WELWYN HATFIELD BOROUGH COUNCIL – DEVELOPMENT MANAGEMENT

DELEGATED REPORT

APPLICATION No: S6/2014/2572/LUP

DESCRIPTION OF DEVELOPMENT: Certificate of lawfulness for a garage extension

DRG: N° 1114-1/3 (A4)

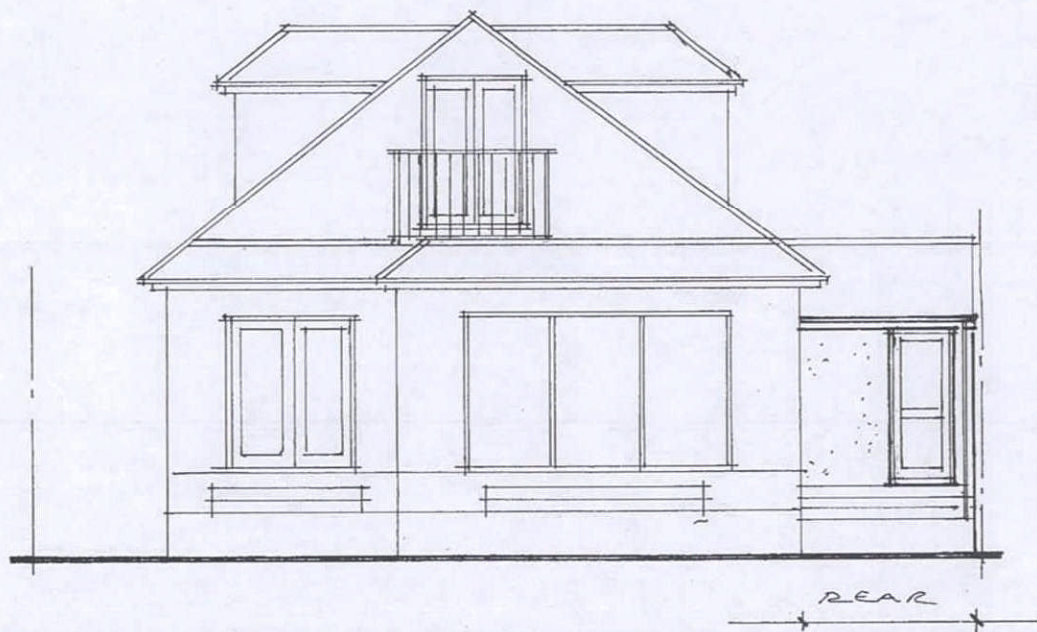
(g) would the enlarged part of the dwellinghouse be within 2 metres of the boundary of the curtilage of the dwellinghouse, and the height of the eaves of the enlarged part would exceed 3 metres	2.9M	N

(h) would the enlarged part of the dwellinghouse extend beyond a wall forming a side elevation of the original dwellinghouse, and:- (i) exceed 4 metres in height, (ii) have more than one storey, or (iii) have a width greater than half the width of the original dwellinghouse	Y N N N	N
